DOC18/112765

Minto Resource Recovery Facility (SSD 7462) – EPA comments on response to submissions

I refer to your email dated 17 January 2018 inviting the Environment Protection Authority (EPA) to provide comment on Minto Recycling Pty Ltd's response to submissions (RTS) on the proposed expansion of its resource recovery facility at 13 Pembury Road, Minto (SSD 7462).

GROUND FLOOR PLAN

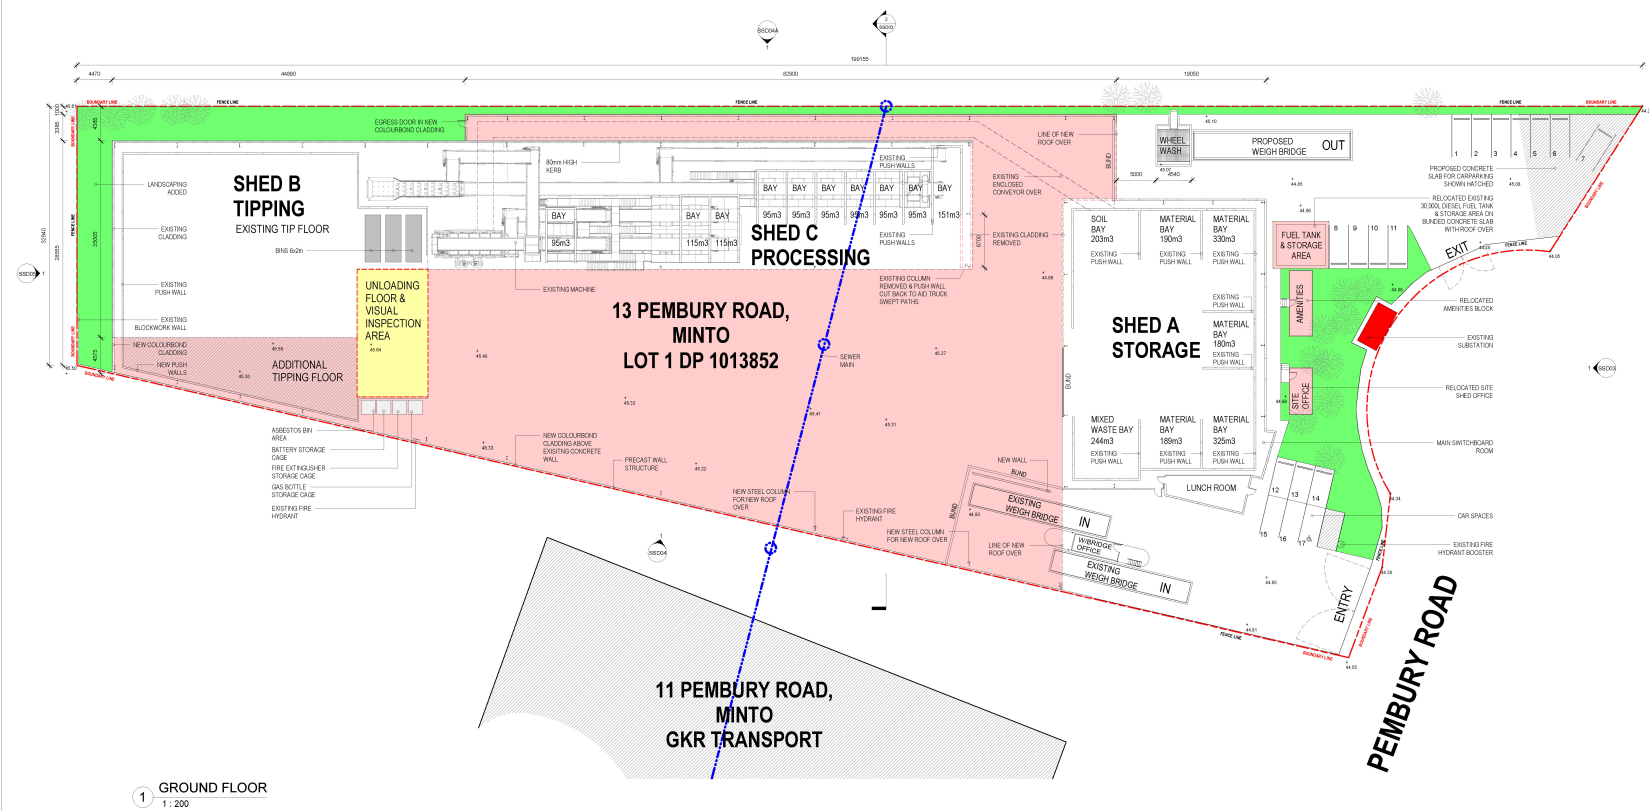
The proponent is seeking to increase the maximum allowable quantity of waste to be held at the site at any one time to 10,000 tonnes. The EPA is of the view that the proponent has not adequately demonstrated that sufficient storage capacity exists at the premises to justify the proposed storage amount. Of particular concern is the proponent's claim that 4920 cubic metres of waste could be stored in Shed B. Assuming a storage area of 1120 m², as stated in the RTS, this would equate to an average stockpile height of at least 4.39 metres (assuming a vertical stockpile) over the entire footprint of Shed B and would limit the floor area available in the shed for the tipping and inspection of incoming loads.

If DPE decides to approve the application, it is recommended that the total amount of waste permitted to be stored on site at any one time remain at 7500 tonnes, as is currently permitted by Environment Protection Licence 20638.
